Location: Land Adjacent to Ferns Northcote Road Langho BB6 8BG
Proposal: Proposed residential development of eight detached dwelling houses (pursuant to variation of conditions 2 (approved plans) on permission 3/2022/0537 and 3/2024/0115. To allow for repositioning of Plot 7).
Grid Ref: 370717 434576

The Local Highway Authority have the following comments to make based on all the information provided by the applicant to date.

Highway Comments:

Drawing Title: **PROPOSED SITE LAYOUT**

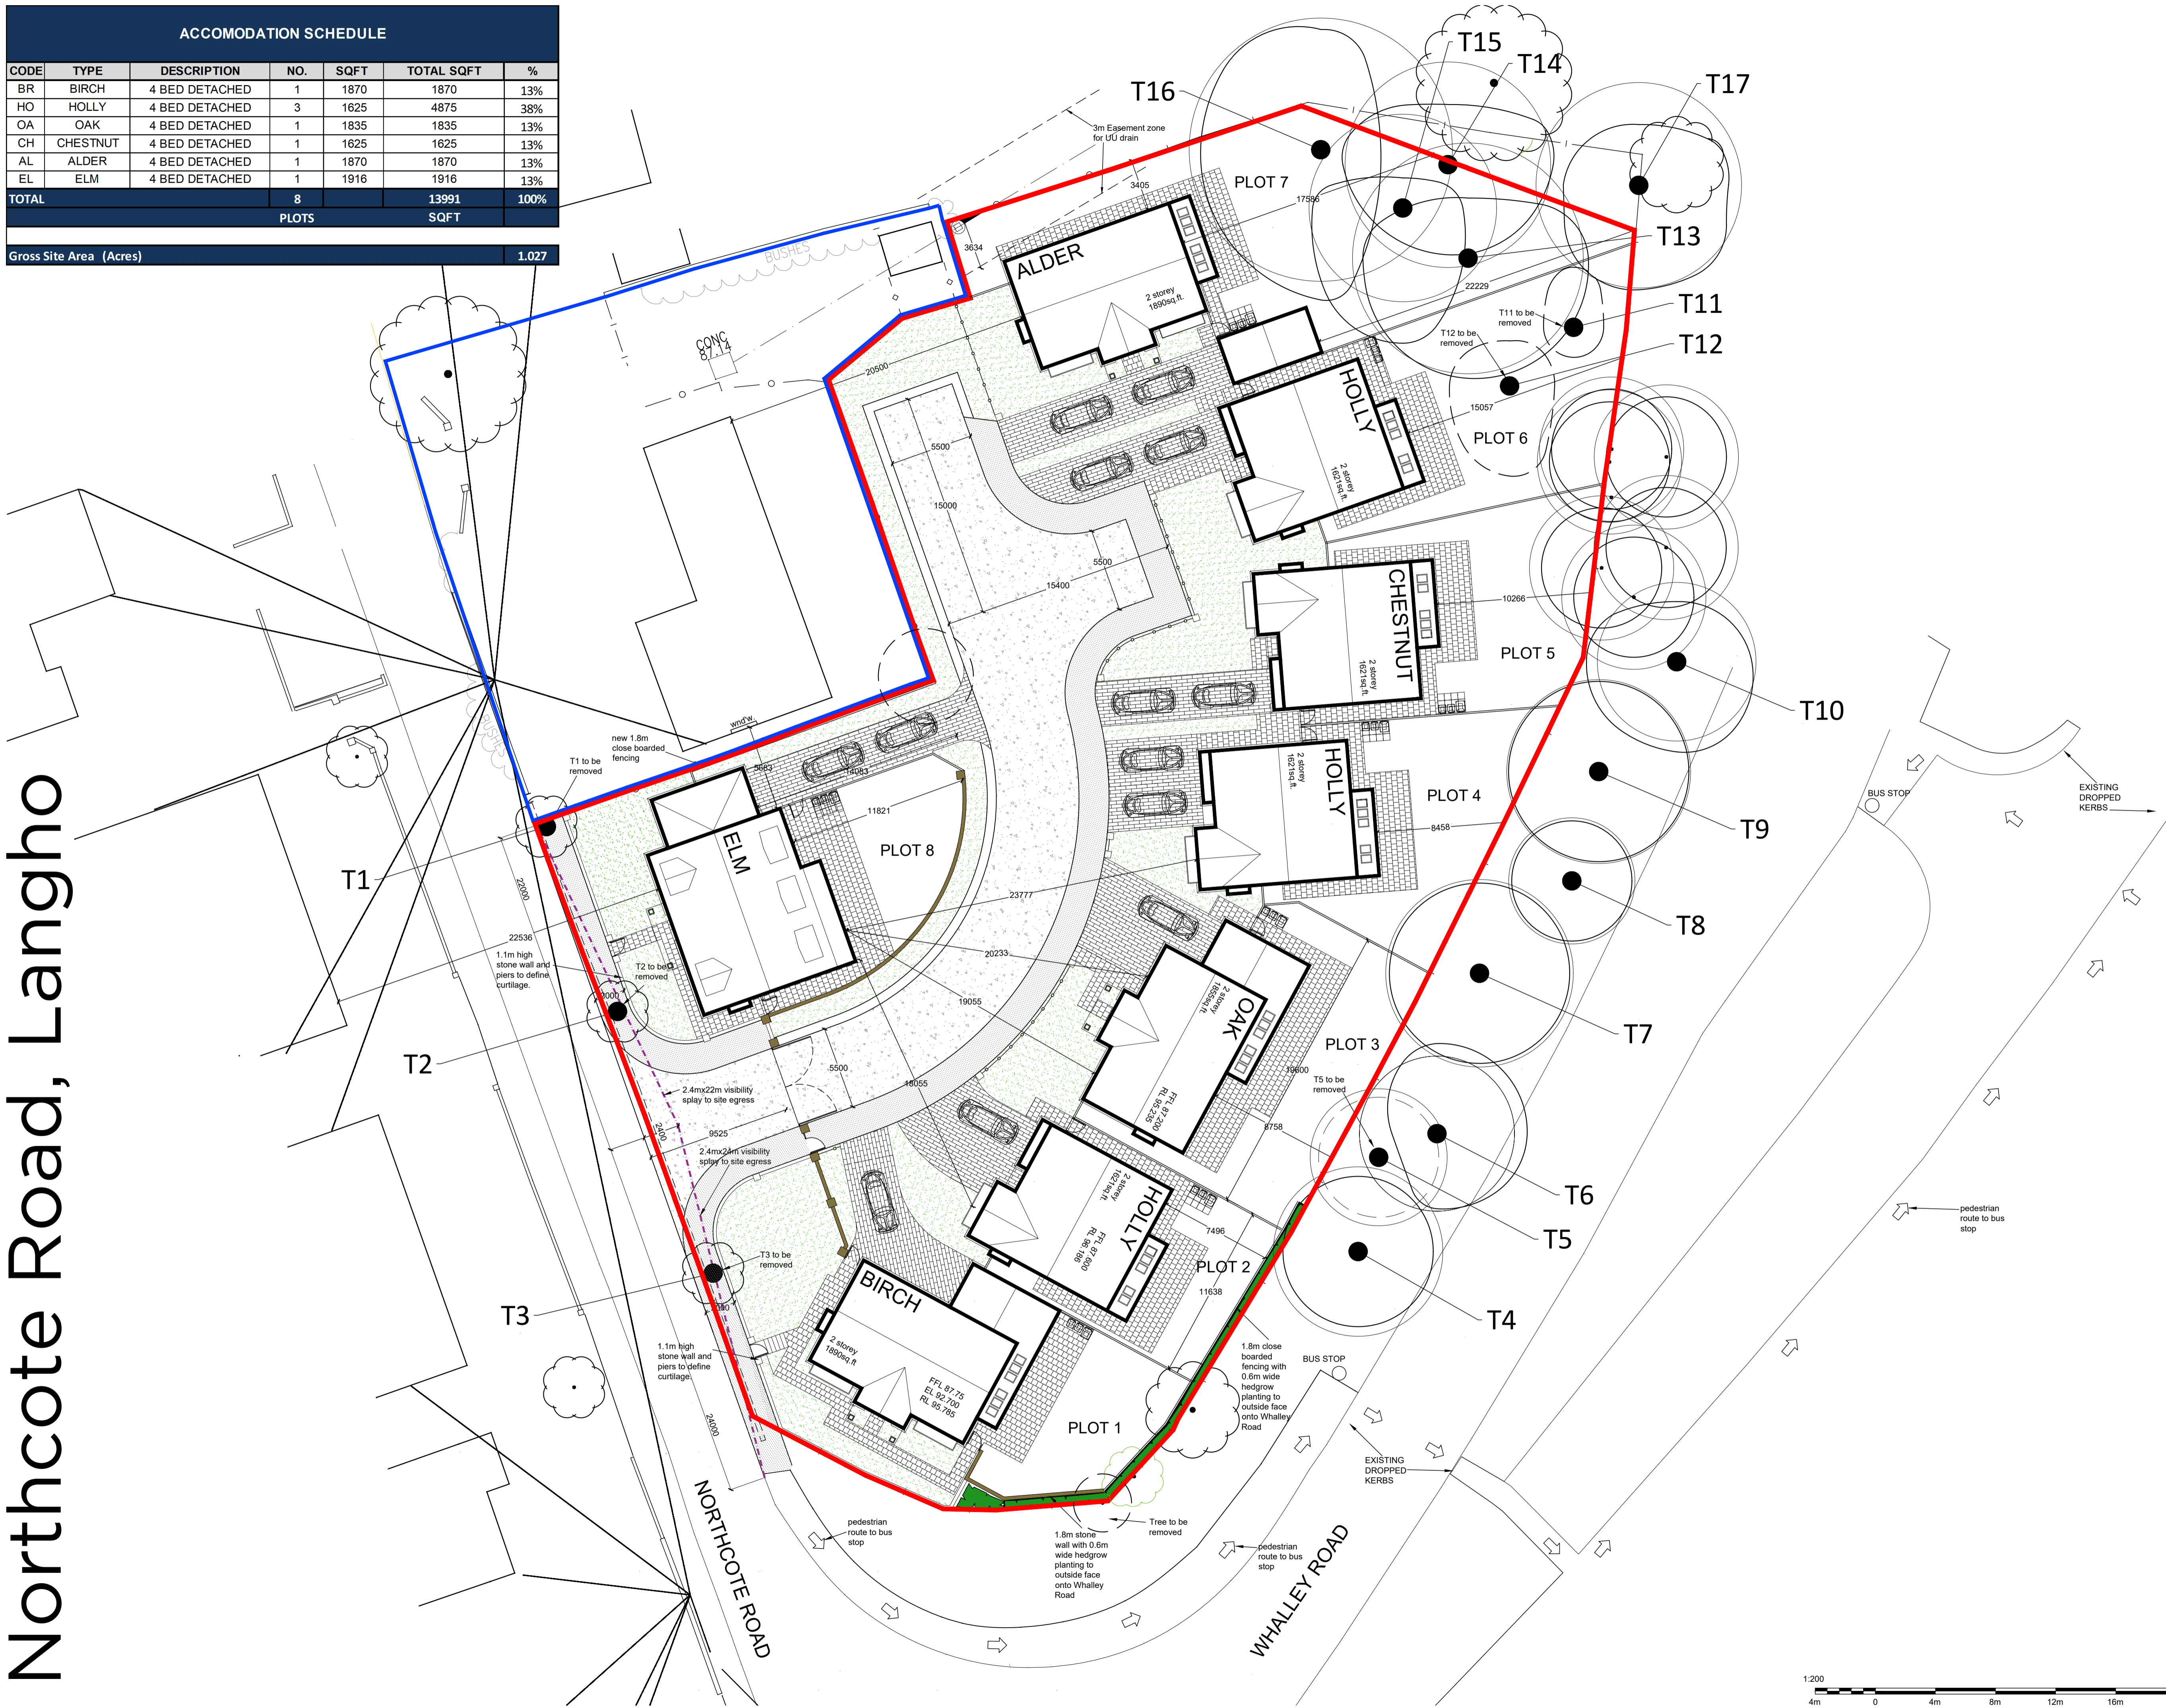
The Highway Development Control Section of Lancashire County Council has no objections to the variation of condition 2. The LHA has reviewed the submitted documentation, the new site plan, drawing number CL_01 Rev N alongside the previously agreed site plan drawing Proposed Site Layout Plan 2203-PL-03K and have no objections to the proposal to reposition plot 7 slightly further into the site.
